**Table 1. RTS Submission - 10424 SSDA**

## Response to Submissions - Government Agencies

SSD 10424 - St Ignatius' College Riverview

Figure 2. Overlay of Stage 2 and approved Concept Proposal (Source: PMDL Architects, 2021)

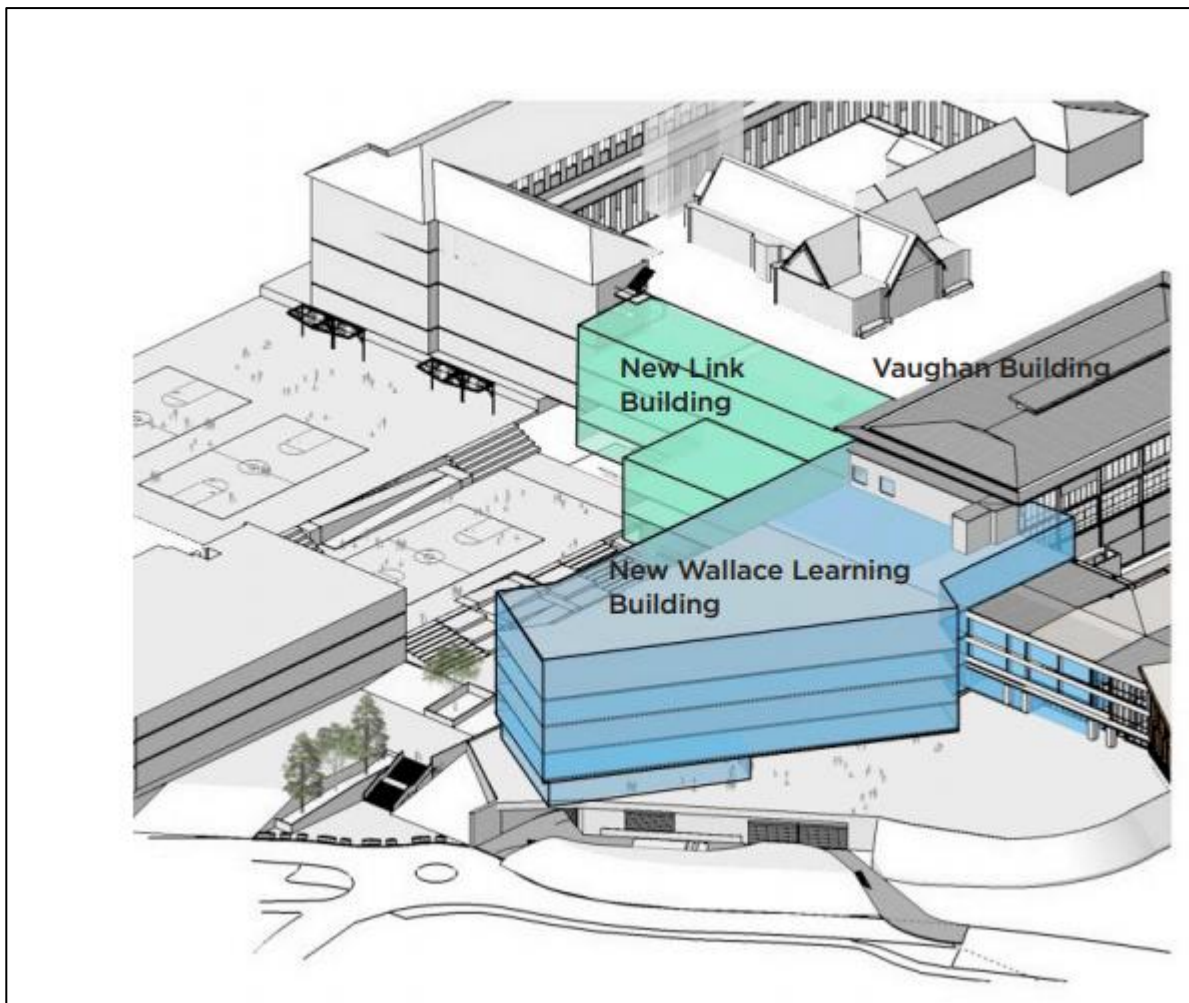
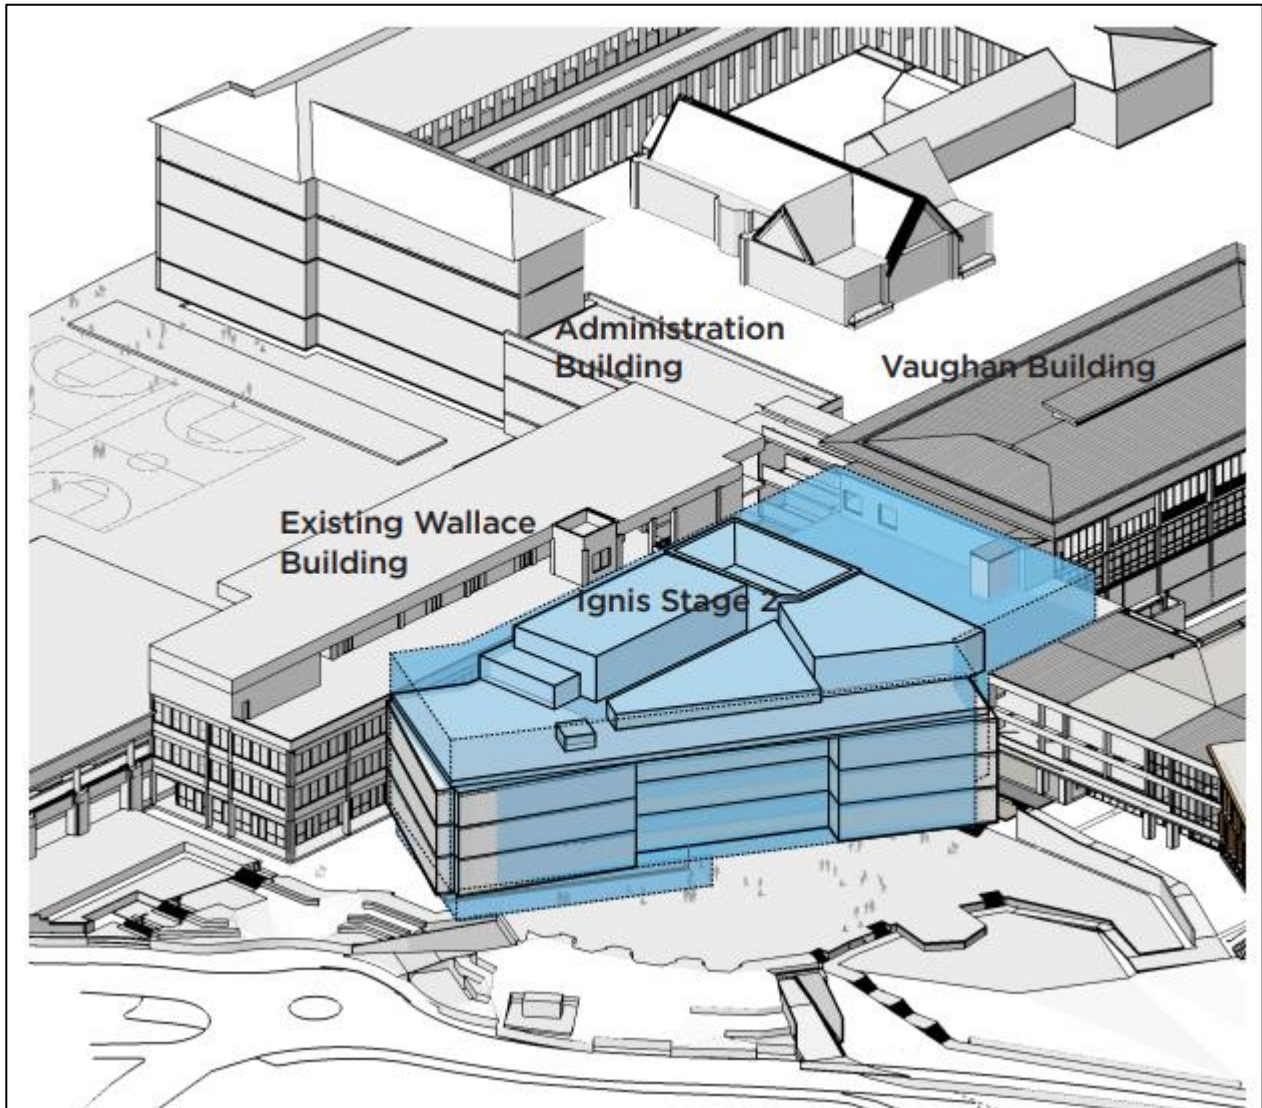
- The EIS does not recognise these inconsistencies nor provides a comparison with the Concept Proposal to demonstrate compliance of the Stage 2 application with SSD-7140. Consequently, the Department requires you to:
  - Provide a table to indicate how this application complies with the conditions of consent for the Concept Proposal.
  - Overlay the Stage 2 detailed plans over the Concept Proposal site layout to demonstrate compliance (or non-compliances) between the proposed and the approved site layouts.

The below table provides a summary of the approved development under the Concept Proposal, particularly as modified under the *Mod 3 Application*, and the proposed Stage 2 works. The approved development that is to be completed as part of Stage 2 is shown in **bold**. It is noted that some of the approved development, specifically the demolition of the existing Wallace and Administration buildings and the new Student Node-Link building works, are separated from Stage 2 and will be subject to further applications.
